Recommendation Report for Planning Permission for Works or Extension to a Dwelling

REF NO: AW/311/20/HH

LOCATION: Mortimer House
2 The Fairway
Aldwick
PO21 4EL

PROPOSAL: Single storey rear extension

PROPOSED GROUND FLOOR PLAN

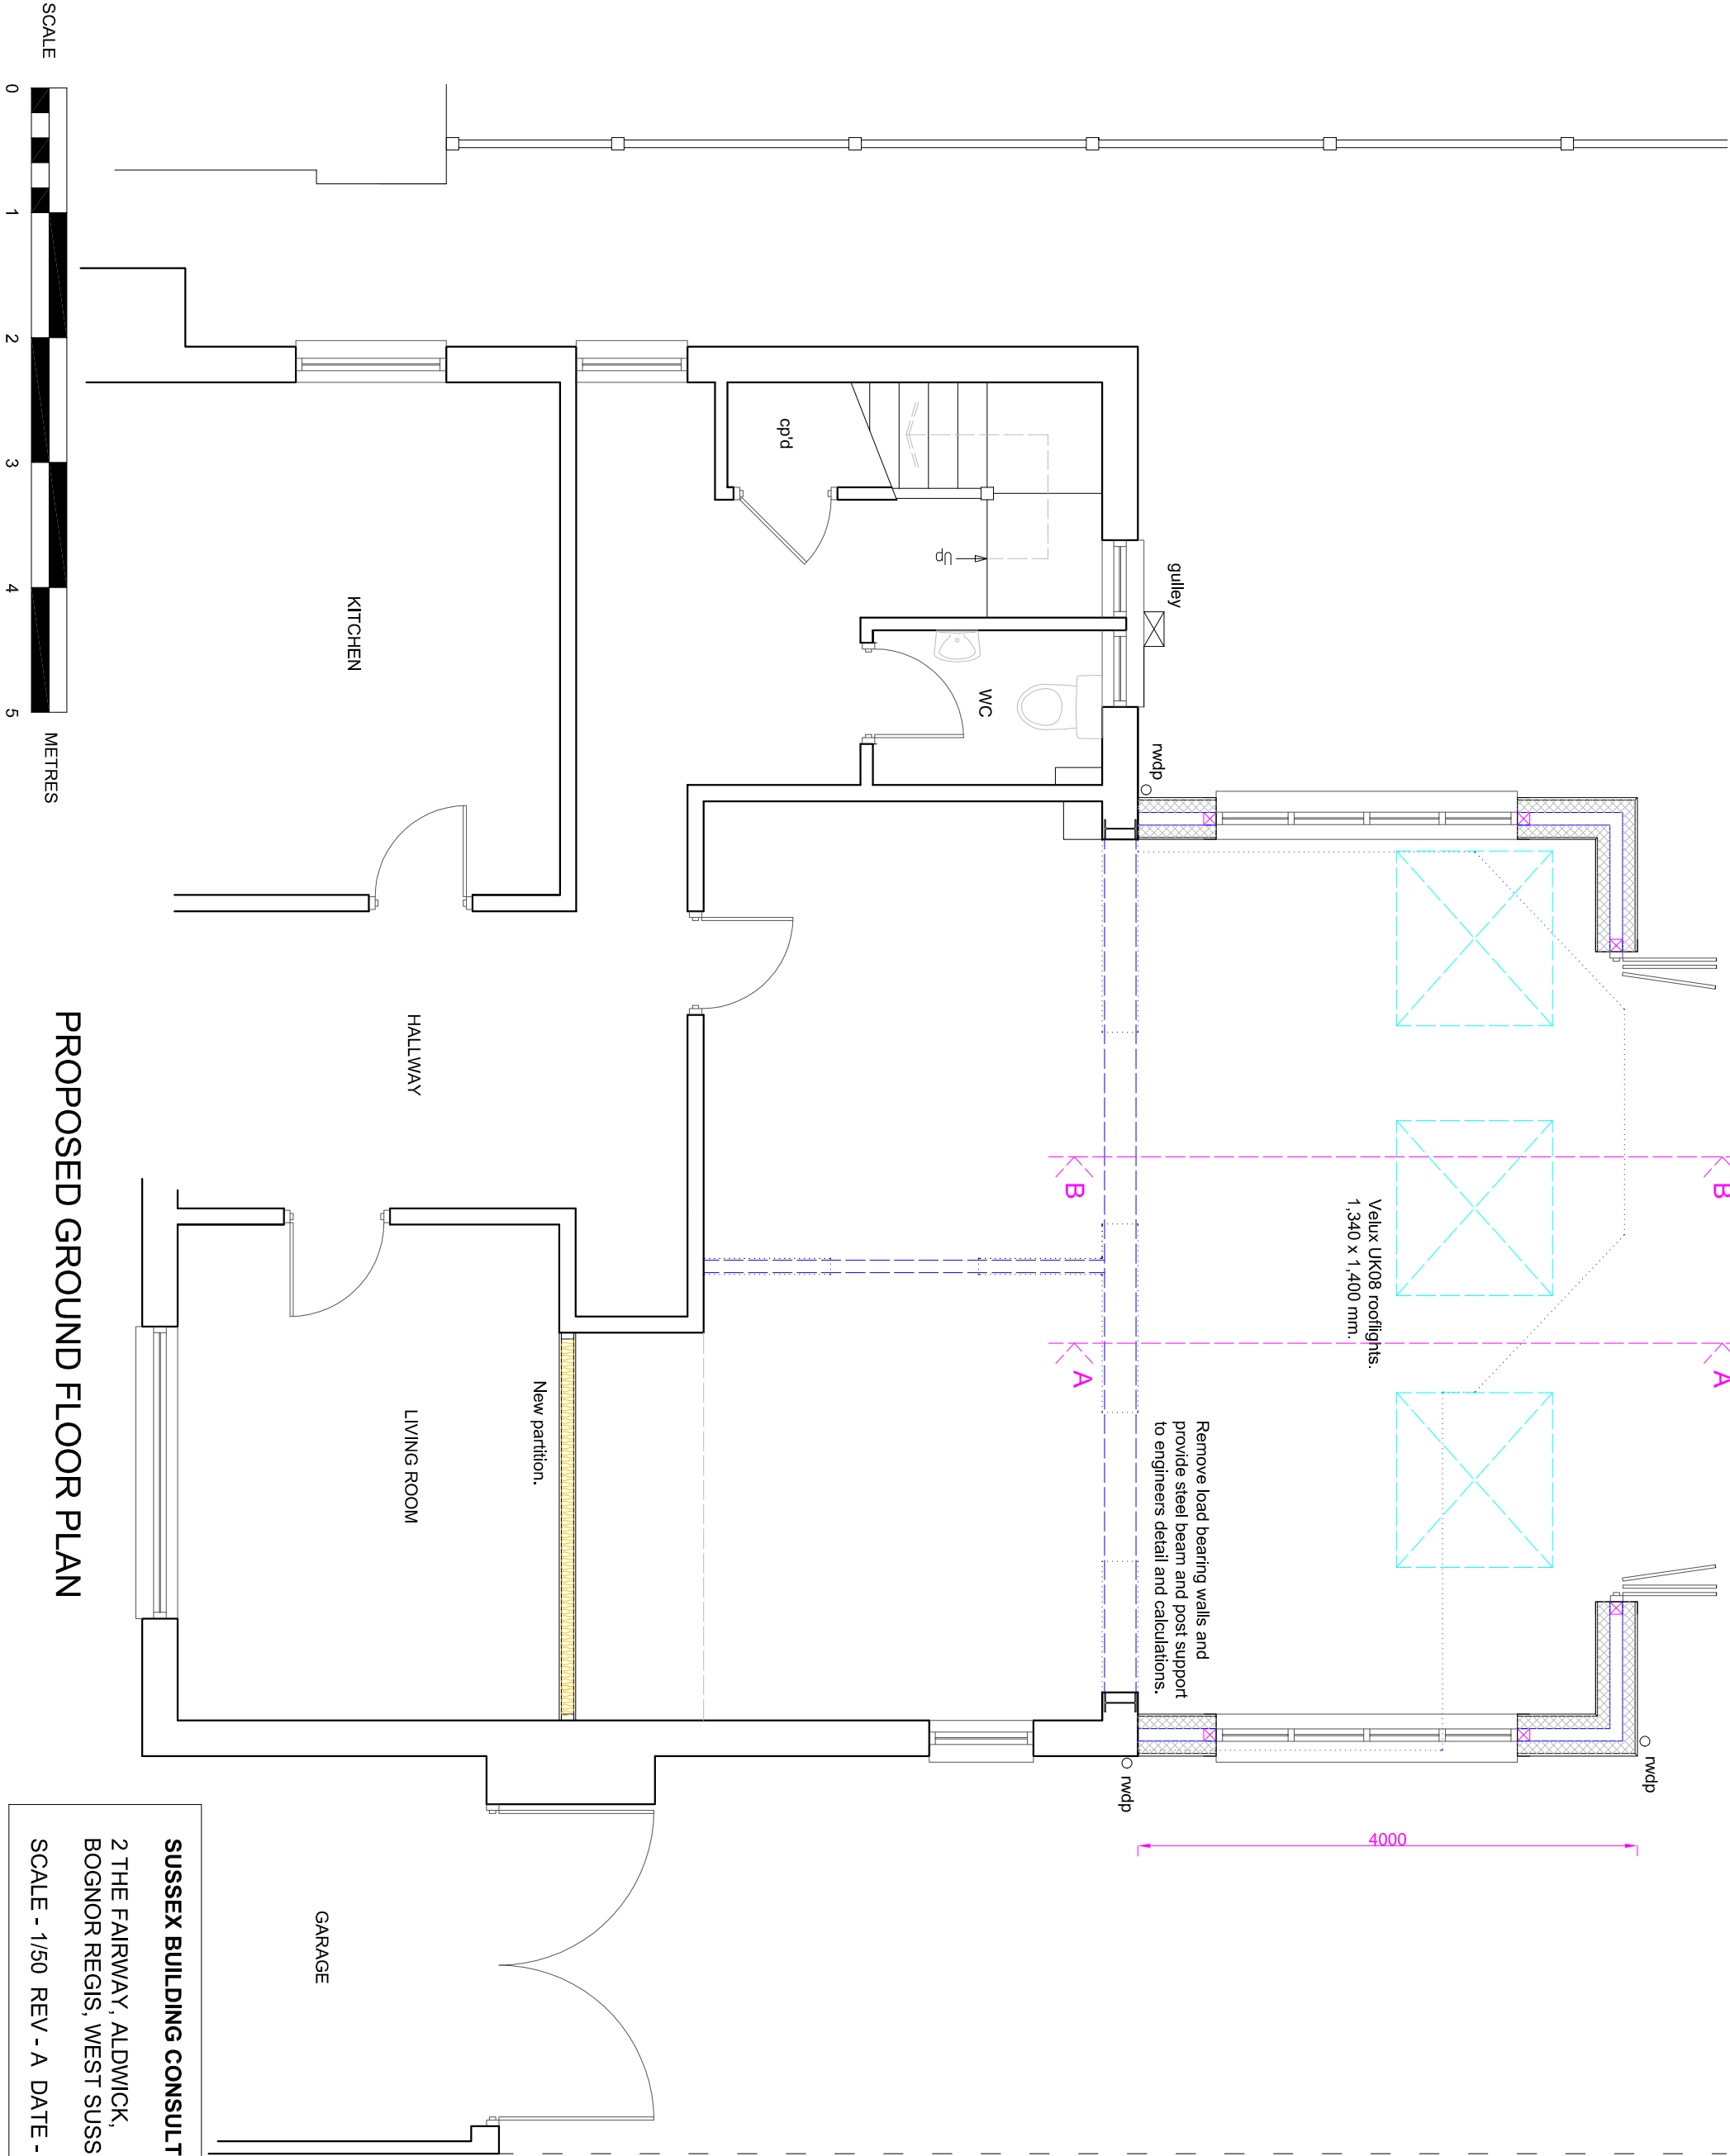
The proposed extension will be located suitable distances from its closest boundaries to the West and East, at 3.1m and 5.2m respectively. Furthermore, views in and out of the garden are partially protected by mature hedging and trees running alongside these boundaries. As the proposal is for a single storey extension it is not believed that it will be overbearing or overshadow the closest neighbours in accordance with policy DDM4 of Arun's Local Plan.

PROPOSED ELEVATIONS

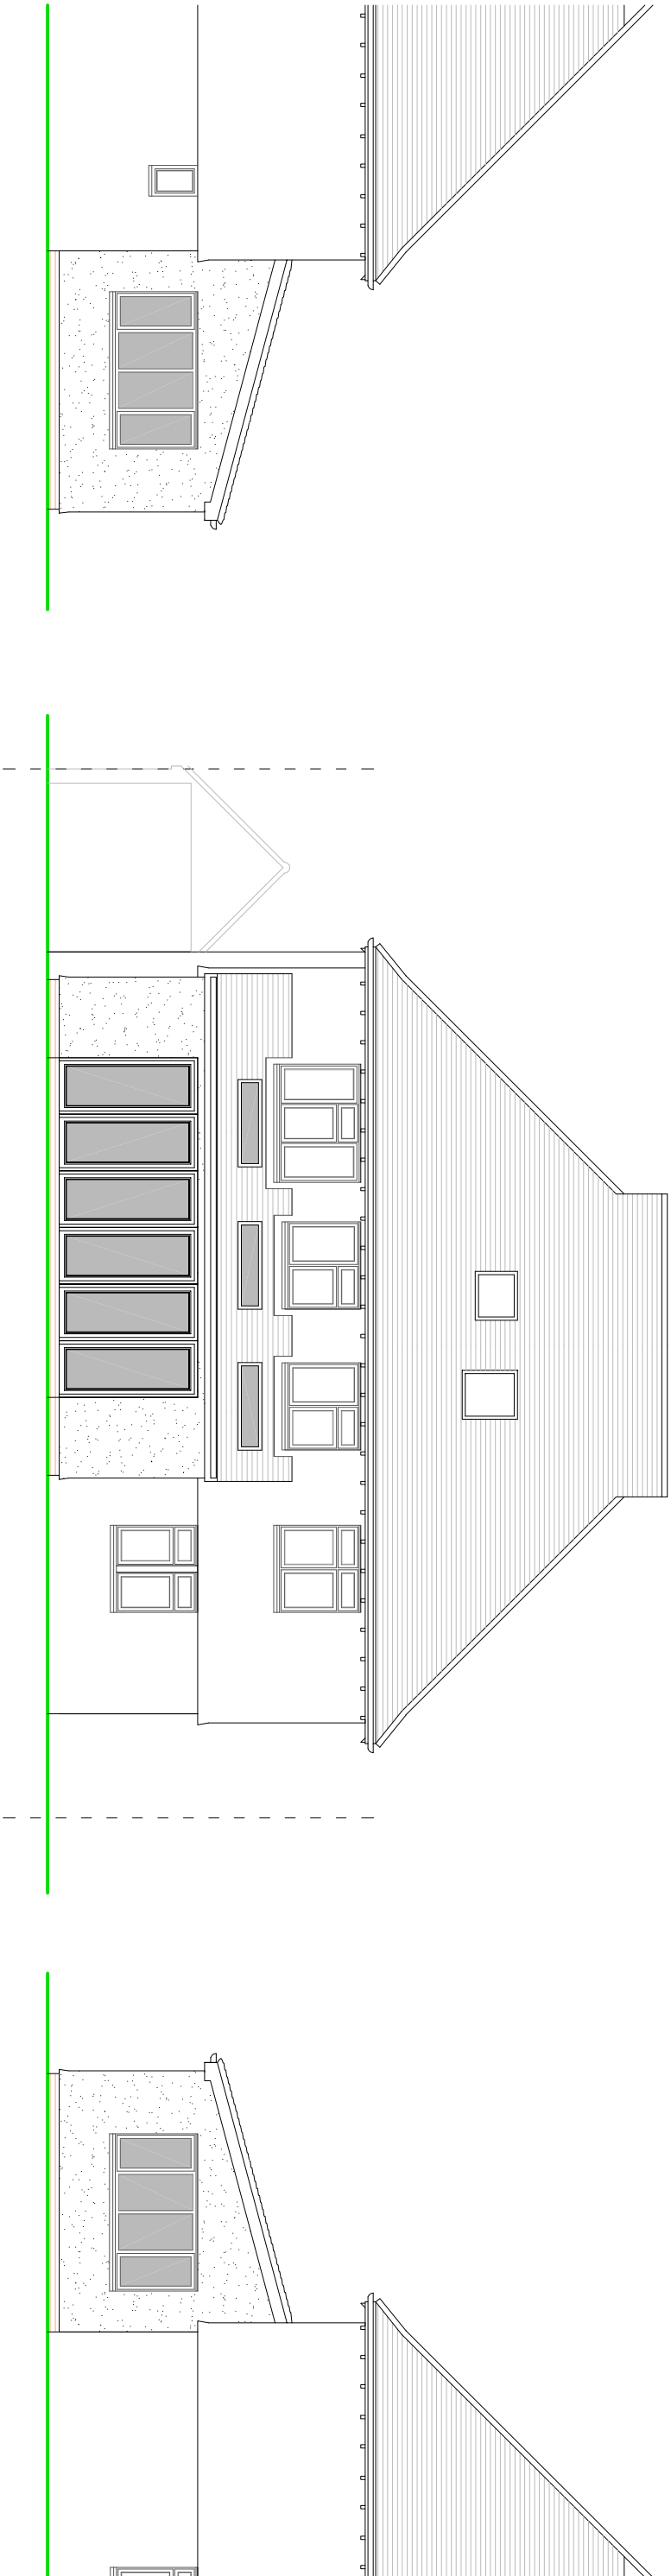
The application seeks to construct a single storey rear extension approximately 7.6m x 4m, with a total height of 3.8m, it is noted that the eaves to the proposed, being single storey, are far lower than the host dwelling therefore, the scale of the proposed extension is thought to be in keeping with the existing dwelling.

The applicant proposes to build the extension in materials to match the host dwelling, including plain clay tiles and painted rendered finish allowing the extension to fit harmoniously within its setting.

The proposed pitch does not match that of the main house giving the extension a squat appearance in comparison, however this can only be view from the limited viewing points to the sides of the extension, West and East, and is not thought to be detrimental to its appearance.

A set of bifold doors is proposed to face South and 2 sets of casement windows are proposed facing West and East. The window which faces East will directly look towards the rear garden of No 1, however it has been noted that the view is blocked by mature hedging and trees on the boundary, which are under the control of No. 1 and therefore no unwanted views are expected be to achieved. The set facing West will predominately gain views of the side of No. 2a, due to No.2a's position further to the South within the plot, therefore it is not expected to cause any undue harm. As such no issues with overlooking are perceived in accordance with policy DDM4 of Arun's Local Plan.
